City of Portland, Maine - Building or Use Permit Application
 389 Congress Street, 04101 Tel: (207) 874-8703, Fax: (207) 874-8716

Permit No: 05-1797	Issue Date:	CBL: 037 C016001
------------------------------	--------------------	----------------------------

Past Use: Commercial/ Tapa Bar	Proposed Use: White Heart Lounge/ install hood in kitchen connected w/ permit#051626	Permit Fee: \$129.00	Cost of Work: \$11,920.00	CEO District: 1
Proposed Project Description: White Heart Lounge/ install hood in kitchen connected w/ permit#051626		FIRE DEPT: <input type="checkbox"/> Approved <input type="checkbox"/> Denied	INSPECTION: Use Group: Type	
		Signature:	Signature:	
PEDESTRIAN ACTIVITIES DISTRICT (P.A.D.)				
Action <input type="checkbox"/> Approved <input type="checkbox"/> Approved w/Condition <input type="checkbox"/> Denied				
Signature: Date:

DWG # :  
**K-1**

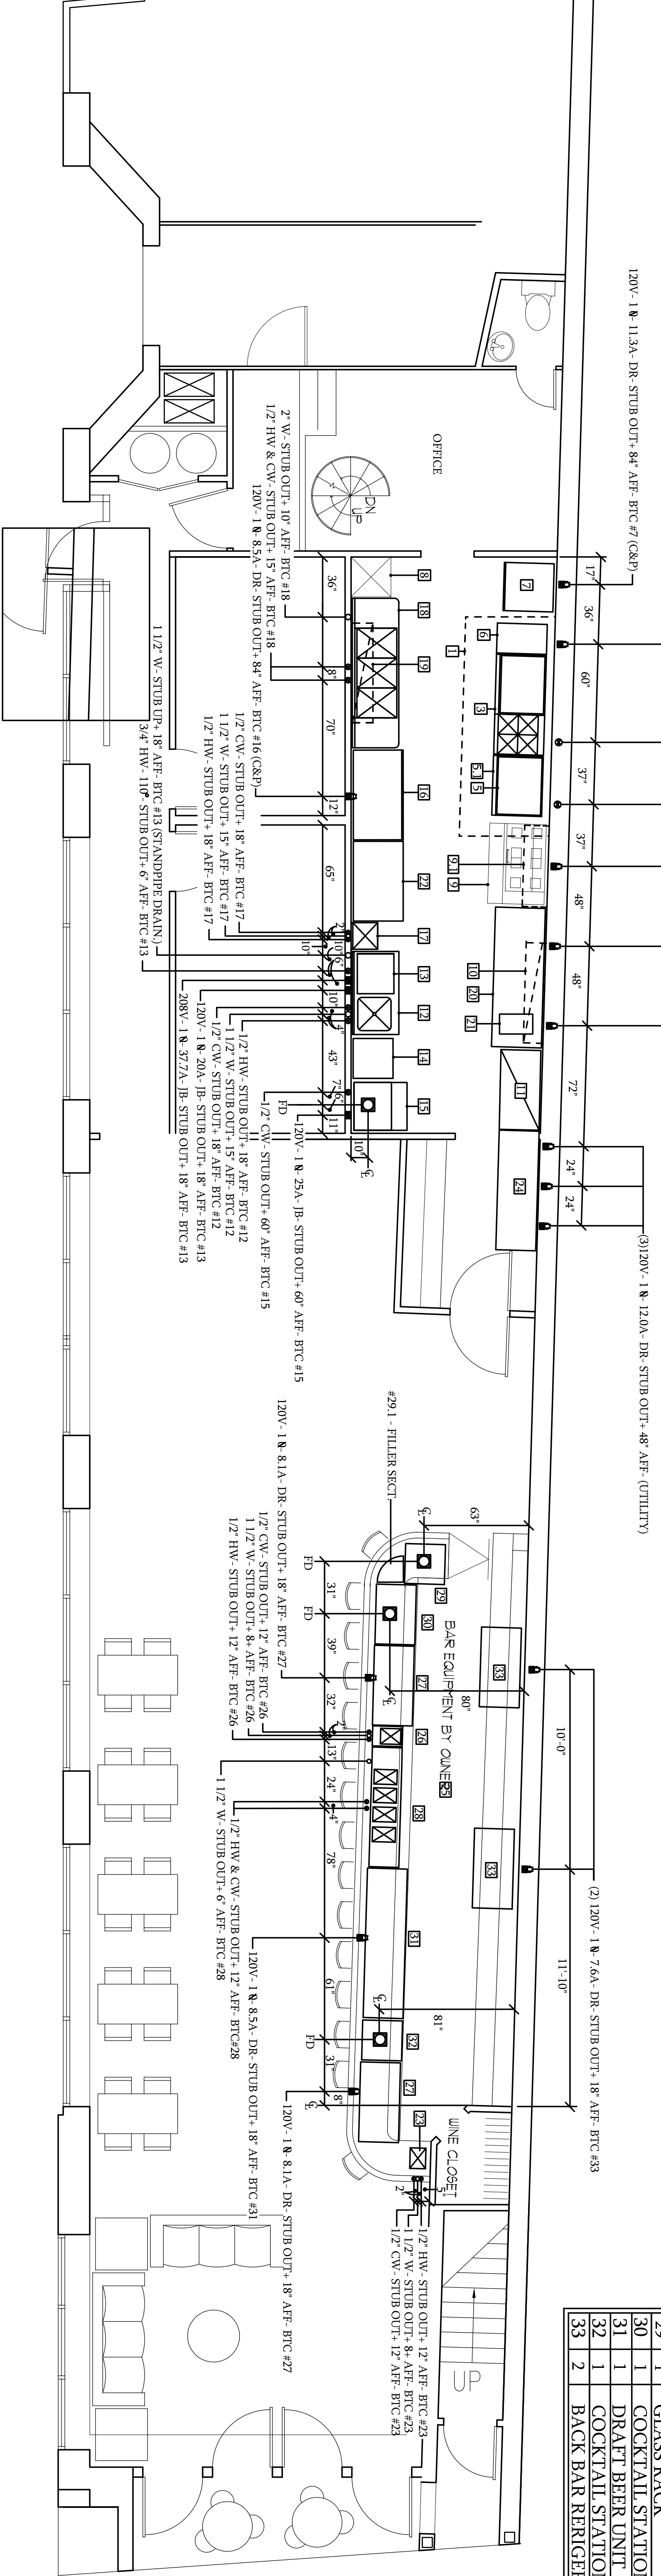
Dept: Building	Status: Approved	Reviewer: Mike Nugent	Approval Date: 03/16/2006
Note:			Ok to Issue: <input checked="" type="checkbox"/>
Dept: Fire	Status: Approved with Conditions	Reviewer: Cptn Greg Cass	Approval Date: 12/15/2005
Note:			Ok to Issue: <input checked="" type="checkbox"/>
1) Install and design to comply with NFPA 96

Comments:
12/16/2005-mjn: Spoke with David Lloyd...need wholistic HVAC plans w/LXS info.
